RWE Renewables UK Solar and Storage Limited

**Proposed Peartree Hill Solar Farm (Application Reference: EN010157)
Second notification of proposed changes to the DCO Application**

SHEET 8 OF 17

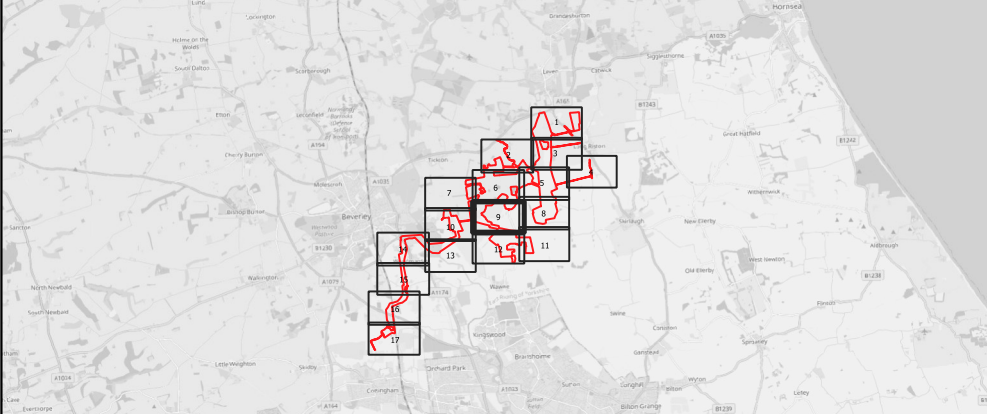
The Applicant has reviewed the proposed vehicular access between Fields C5 and C8. In the DCO Application as submitted, this was proposed to be taken via the existing crossing of Arnold and Riston Drain linking Field C5 with Field C8 (see sheet 8 of 17 of **ES Volume 3, Figure 3.4: Indicative Environmental Masterplan [APP-058]**). The crossing would then enable access to be taken to the southern fields in Land Area C, namely Fields C6, C7, C8 and C9.

However, following a further review of the existing crossing, the Applicant does not consider that it is suitable to accommodate construction vehicles. A new crossing of Arnold and Riston Drain is therefore proposed, linking the south-eastern corner of Field C5 with the north-eastern corner of Field C8. Building a new bridge would be preferable to reinforcing the existing crossing due to the turning angle needed by the construction vehicles and existing complexities in bridge layouts. The bridge would be constructed to a standard appropriate for use by construction vehicles and would be left in situ for the lifetime of the Proposed Development to enable access to be taken to Fields C6, C7, C8 and C9 for maintenance. Plans of the crossing would need to be submitted in advance for the approval of Beverley and North Holderness Internal Drainage Board in accordance with the protective provisions for drainage authorities in Part 3 of Schedule 12 to the **draft DCO [PDA-012]**.

The proposed new crossing location would also enable some simplifications to be made to the access tracks in this location. In particular, rather than laying two access tracks either side of the Dike, a single track to the south of the Dike would be sufficient.
